EPA Advice on Submissions Report

Thank you for the request for advice from Public Authority Consultation (PAE-15712002), requesting the review by the NSW Environment Protection Authority (EPA) of the Response to Submissions Report for the proposed New Berrima Brickworks facility (Application SSD-10422) at 416 and 524 Berrima Road, Moss Vale (Lot 1 DP 785111 and Lot 1 DP 414246).

Attachment A
Review of Response to EPA Advice on Submissions Report prepared by Airlabs
Environmental – 25 February 2021.

Figure 1: Extent of Exceedance of the 24-hour average HF Concentrations on Impact Area 2 (Represented by the Solid Orange Coloured Area)

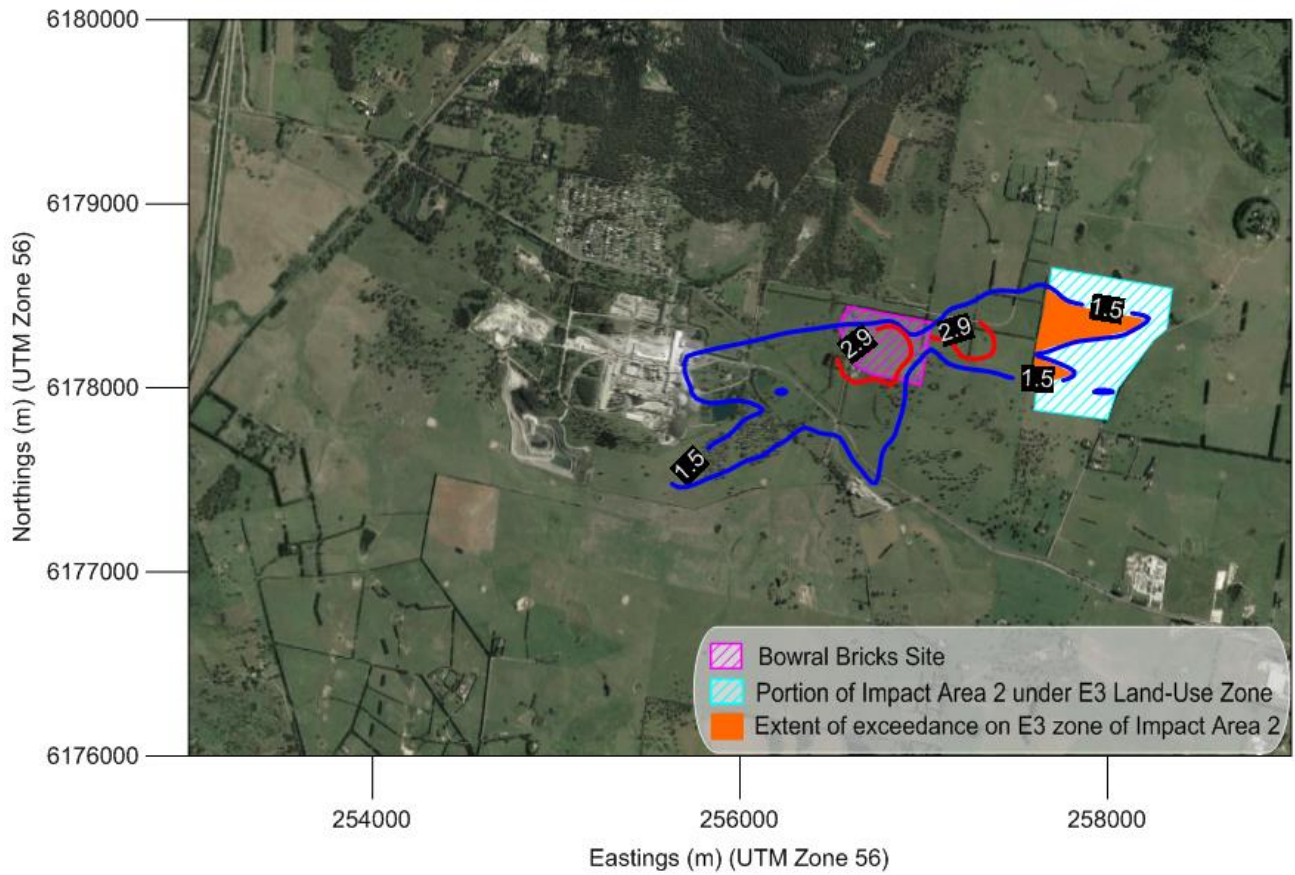
No further assessment of Hf emissions was undertaken. As such, minor exceedances of the EPA's Hf sensitive land use criterion of 1.5 ug.m^3 (24-hour average) are still predicted to occur on land zoned E3. Future potential land use in the potentially affected areas may be impacted. An area of approximately 10ha is likely to be impacted as shown in Figure 1 below.

The EPA advises the Department of Planning, Industry and Environment (DPIE) that the results of the dispersion modelling show predicted impacts above the EPA's impact assessment criteria in the land zoned E3 to the North West of the proposed facility. Future specialised land use potential in this area may be affected, including vegetation sensitive to fluoride, such as grape vines and stone fruits.

The proponent has committed to install a cascade scrubber, designed for treating kiln emissions, which is in line with best practice Hf control. The scrubber should be capable of achieving an emission performance below 20 mg/m^3 on an ongoing basis. The adopted emission concentration of 20 mg/m^3 is considered to be conservative and that the associated Hf impacts may be overpredicted. Notwithstanding this, the assessment demonstrates that best practice control and management of Hf emissions are required to ensure impacts on nearby future land use planning are minimised.

The EPA has recommended strict emission limits and monitoring conditions be applied to regulate the performance of the plant. The EPA has also recommended a condition for post commissioning emission monitoring following the commencement of operations.
